THE SHOP'S AT MERIDIAN RANCH

PHOTOMETRIC PLAN

Shop's @ Meridian Ranch
Site Development Plan
Meridian Road
Falcon, CO

FILE NUMBER: PPR18033

DRAWING NO. **4**
PHOTOMETRIC PLAN

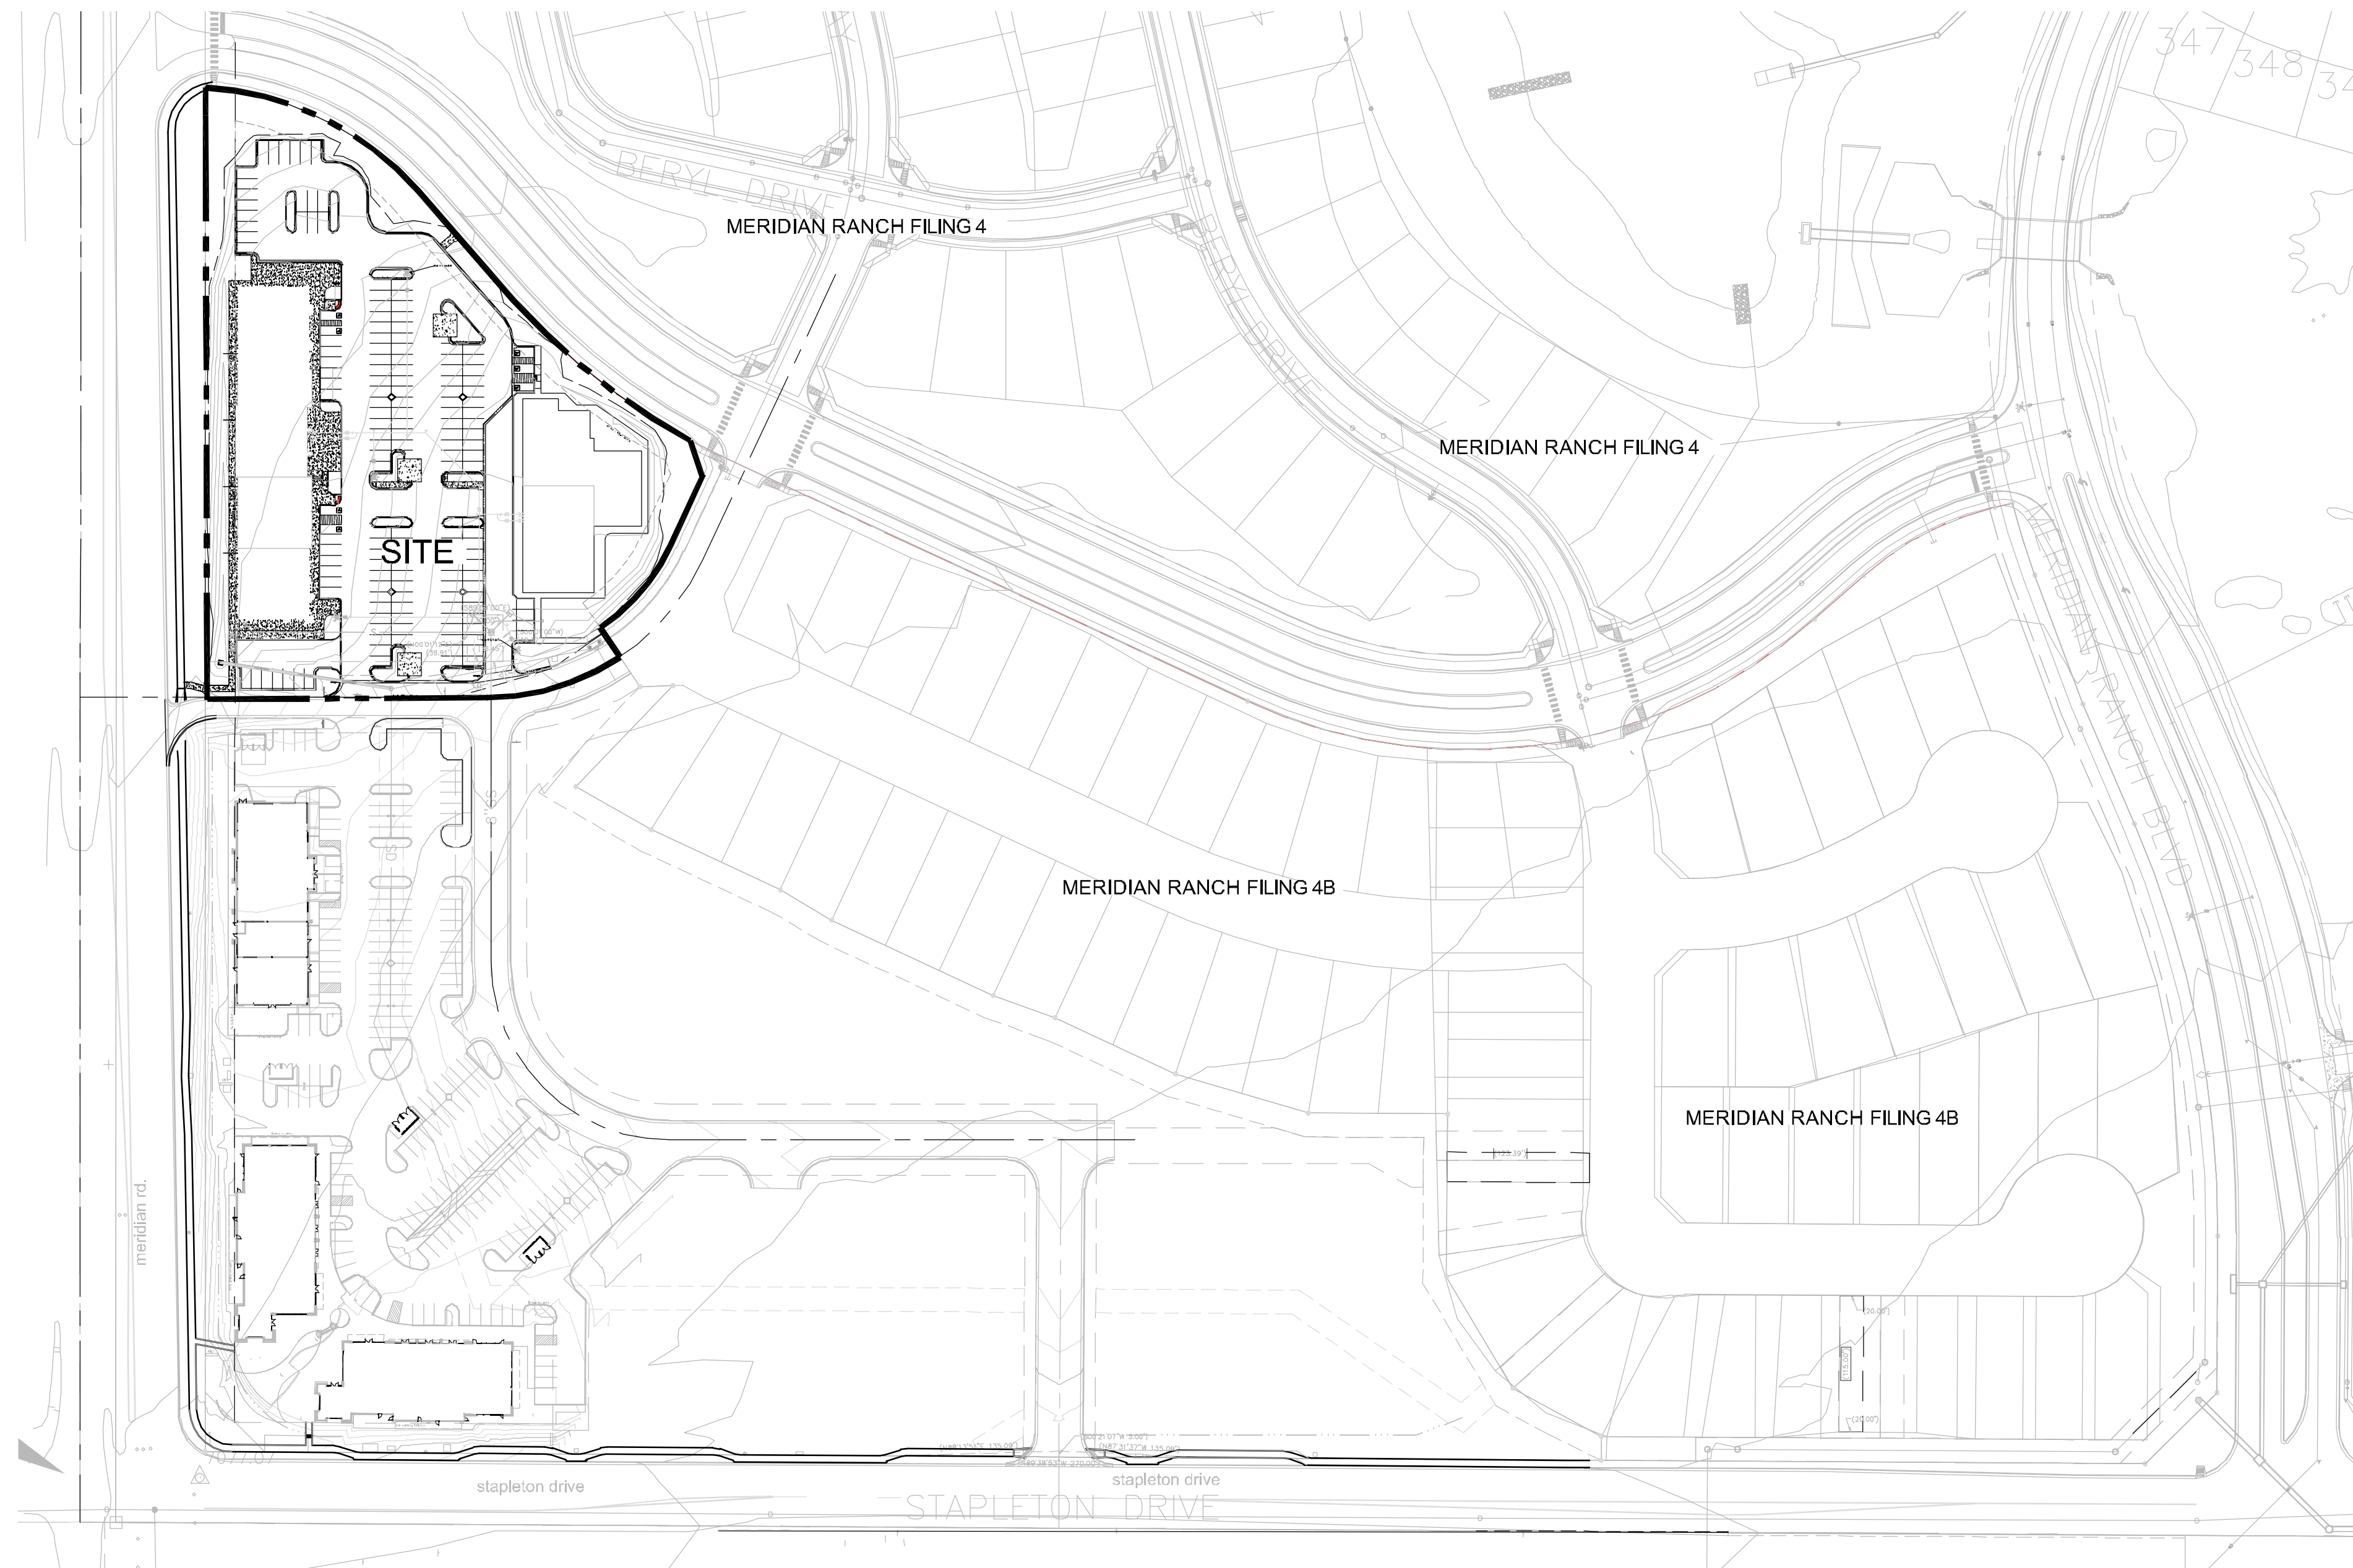
Max lighting of 10 fc unless at a loading area.

Cannot exceed 0.1 foot candles at property boundary adjacent to public R.O.W.
